Response to Planning Application

From: Arun District Council Greenspace

Application ref: AL/113/21/OUT

Location: Land at Bayards Level Mare Lane Eastergate PO203RZ

Figure 4.7 Landscape Play Strategy (fabrik, 2021)

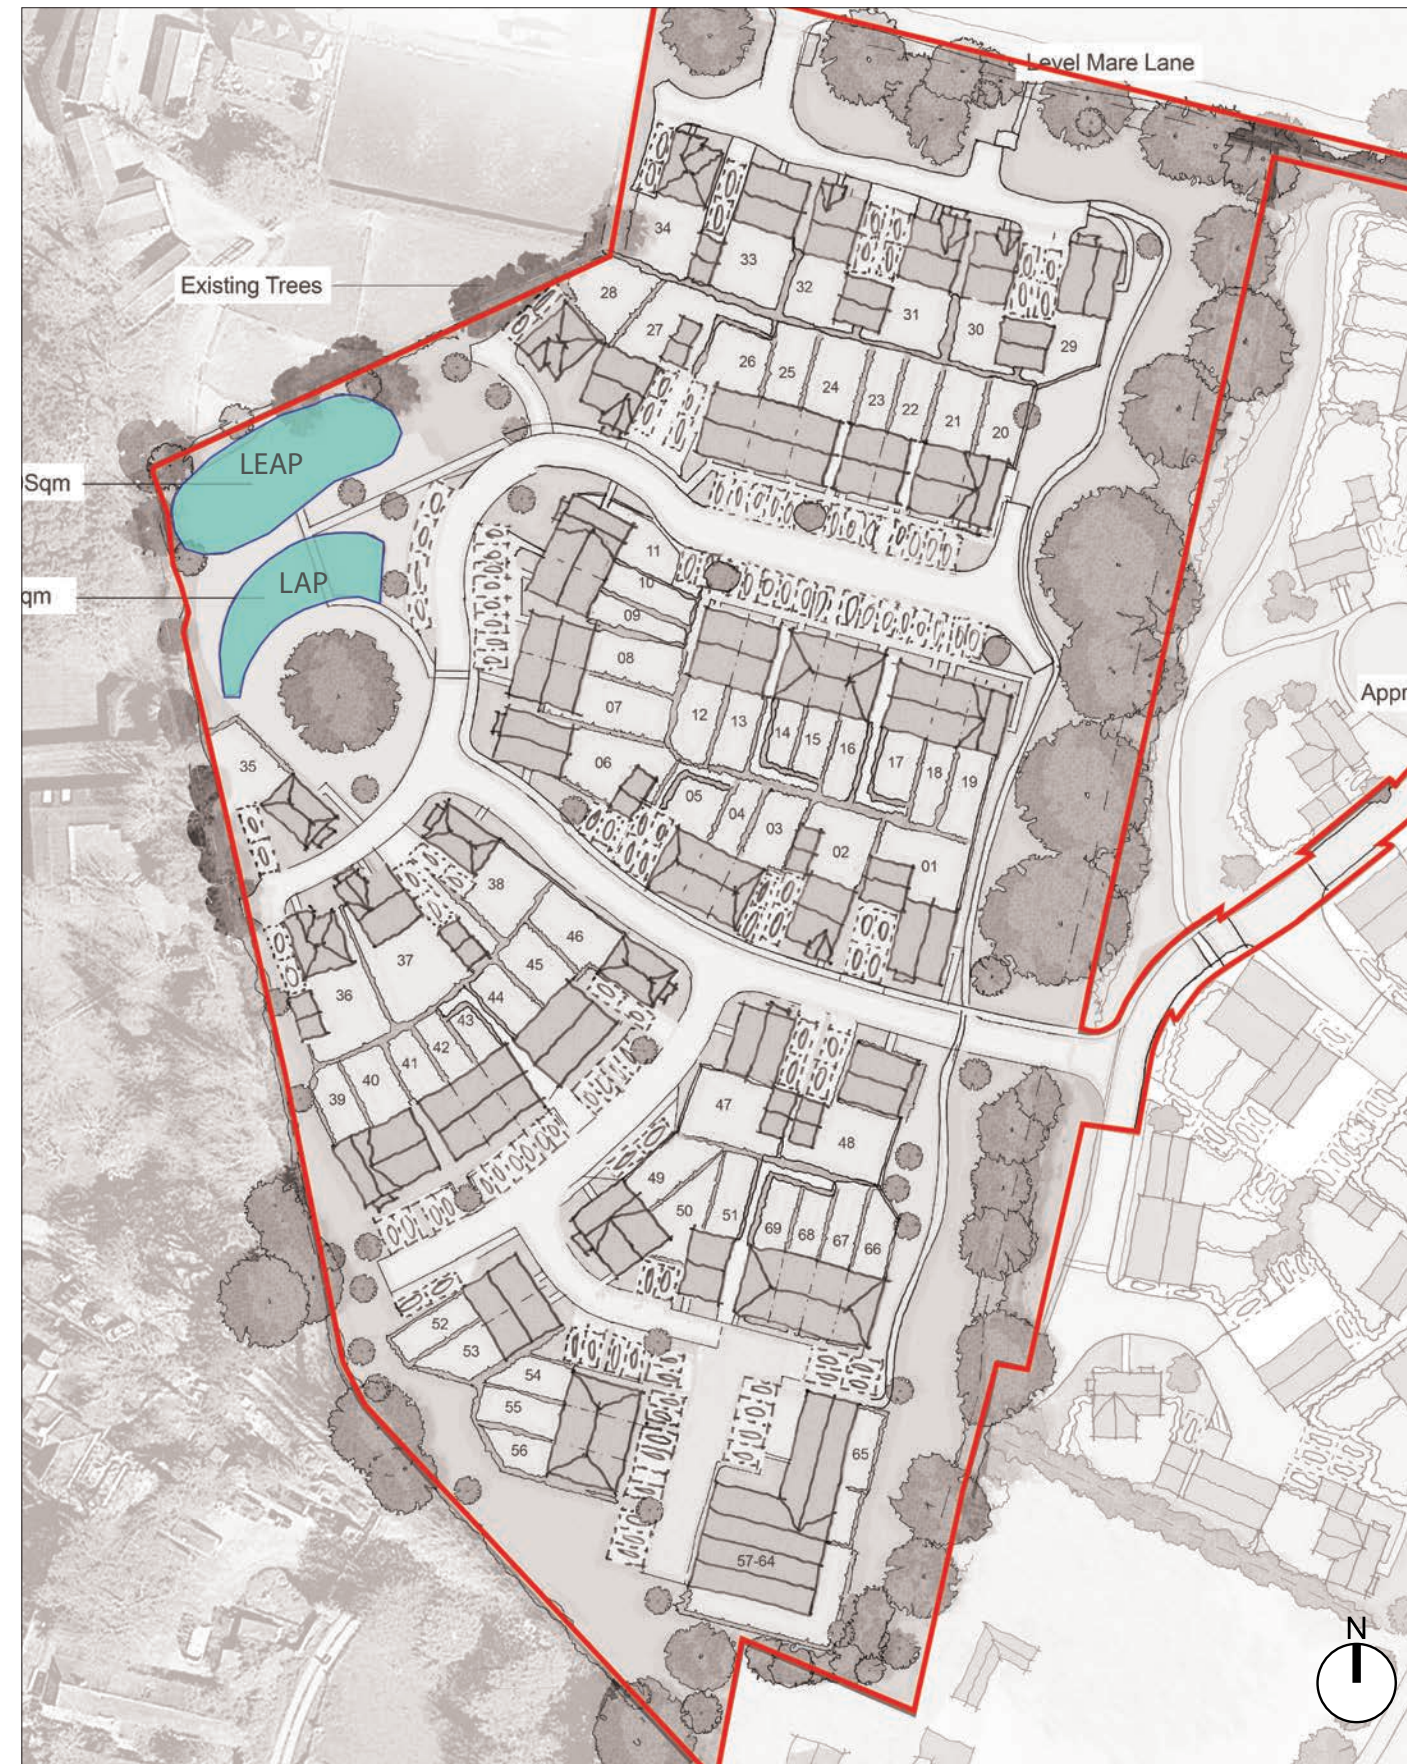
This development will trigger the requirement for play in the form of onsite LAP and LEAP provision, which have been shown in indicative form, located to the western POS area. The play offer would need to be accessible and inclusive in line with Aruns Design Guide SPD Jan 2021, a joined up approach and connection to the trim trail equipment approved within the site to the east would be encouraged and re-locating the shown LAP in this location may be beneficial. Equipment choice, surfacing, pathways, seating/bins and possible fencing would need to be submitted for approval.
